# PROPOSED FRONT SETBACK VARIANCE

SITE PLAN

MOORE RESIDENCE  
10155 CHIPITA PARK ROAD  
GREEN MOUNTAIN, COLORADO 80819

PROJECT NO: RA-1-19

SITE PLAN
(THIS IS NOT A PROPERTY SURVEY)

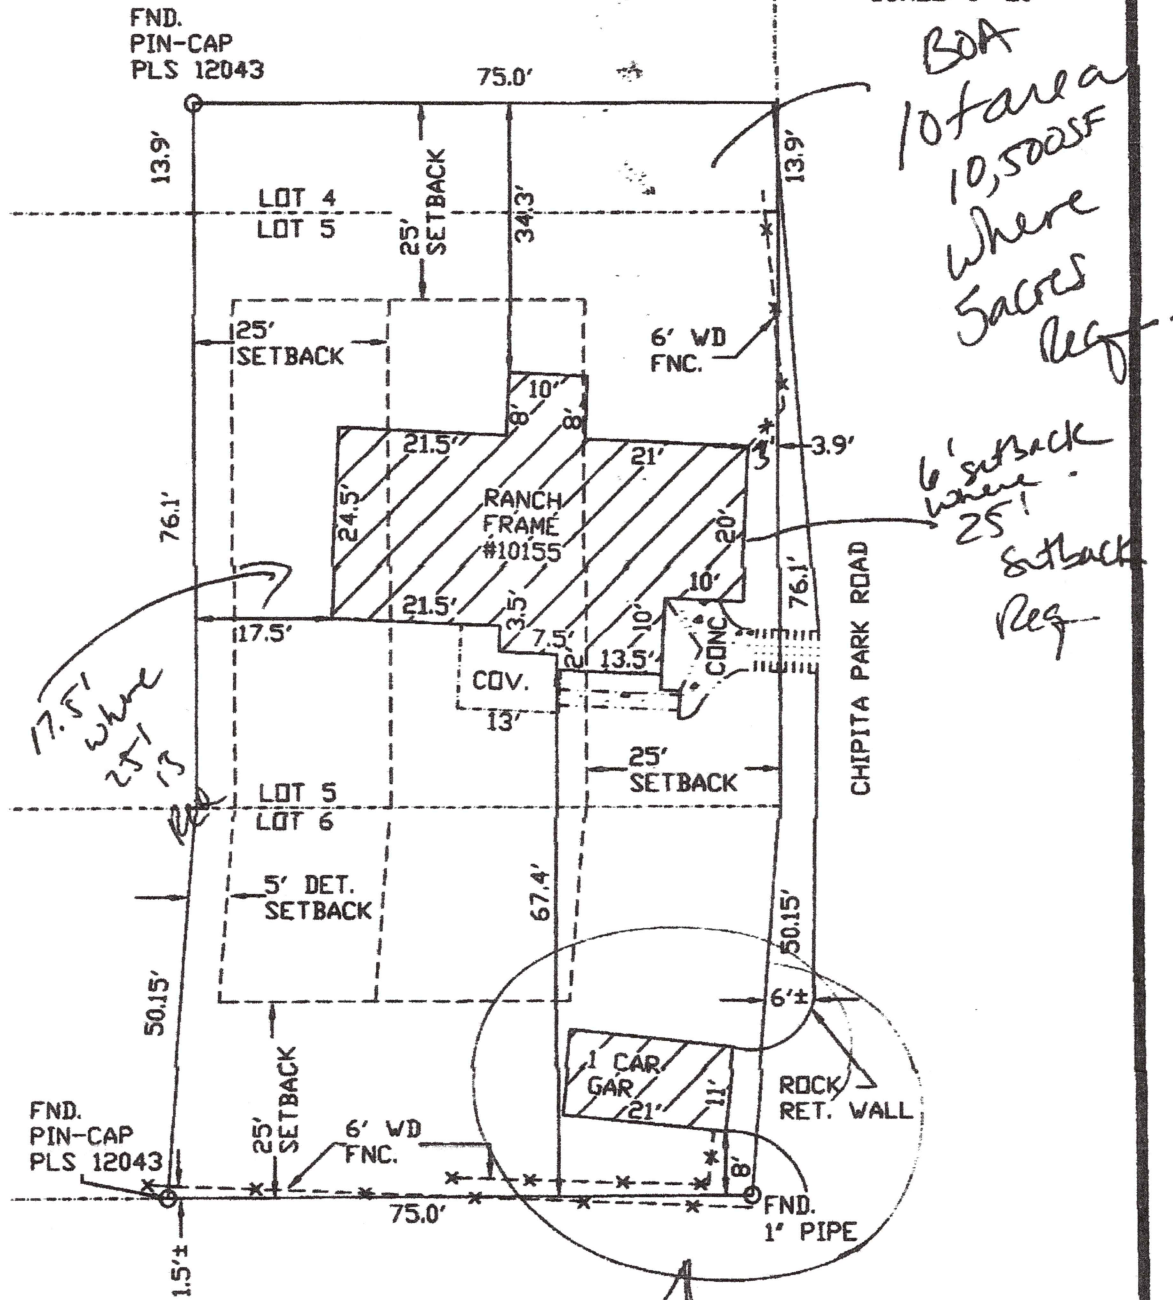
Show lot coverage percentage.

Show 25 foot setback

Show marking of  
where the potential  
10 foot right-of-way  
expansion line is.

Show this as the  
setback to the  
principal dwelling,  
differentiate it from  
the proposed  
structure.

Show proposed  
setback for proposed  
structure only.

License agreement  
required.

Show actual Right-of-way.
